PORTLAND MAINE

January 15, 2010

RE: 16 City Point Road, Peaks Island – 087-S-009 – IR-2 Zone with a Shoreland Overlay

Plan for removal of existing sliding door at 16 City Point rd. Peaks Island.

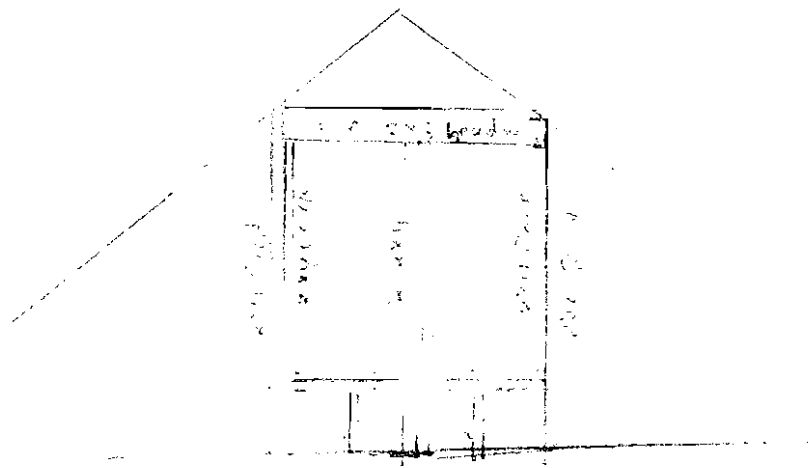
In 1999, the previous owner, Covey Johnson, maximized the 30% floor area and there is approximately 200 cubic footage of volume left to use. A recent inspection by our Code Enforcement Officer revealed unpermitted changes to the structure. There is now a door and a deck off the 2nd floor. This work violates the maximum 30% allowance under the Land Use Ordinance. These changes must be removed before any permits are allowed on the property.

It will be necessary to submit a plan of action to remove the illegal 2nd floor deck and door within ten days of the receipt of this letter. I will glad to make an appointment to review the history of the property with you. We can also go over any alterations you may want to do concerning the property.

plans showing changes to house at 16 City Point rd. Peaks Island

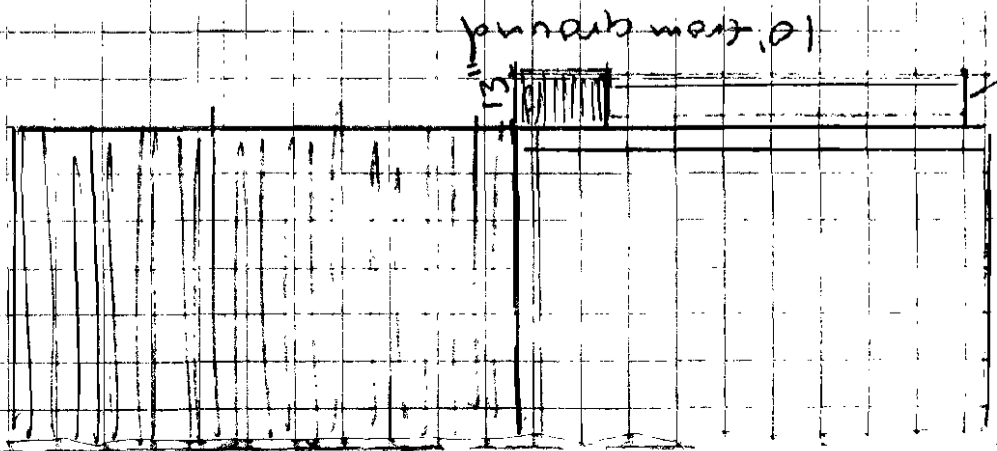
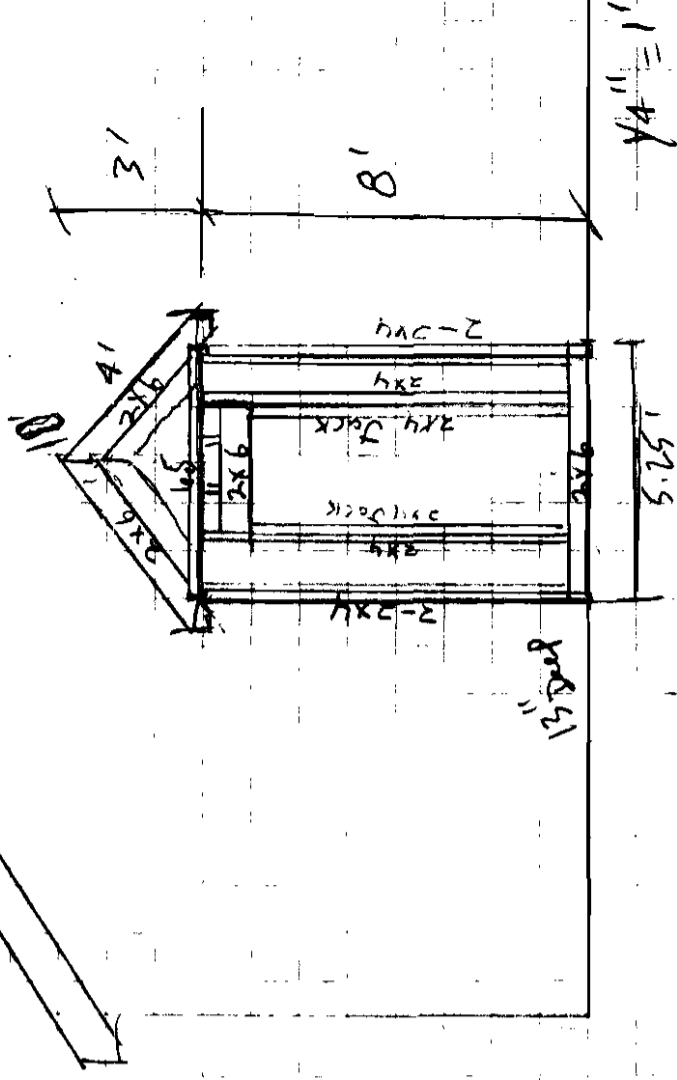
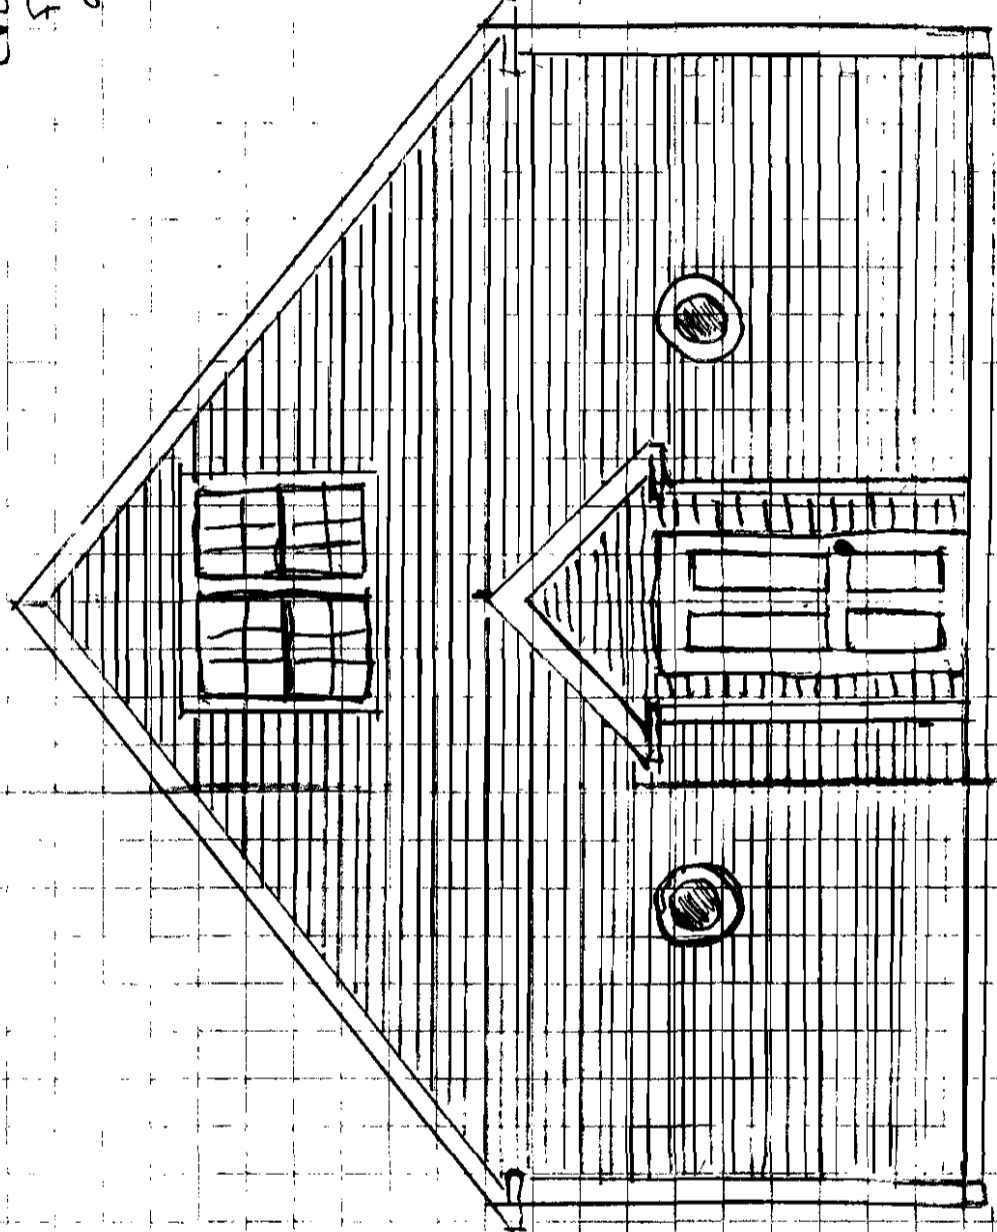
This new application does not discuss additional volume changes for a false door enclosure along the road. Since that work is considered volume, you must apply for permits and meet the requirements of Shoreland Zoning.
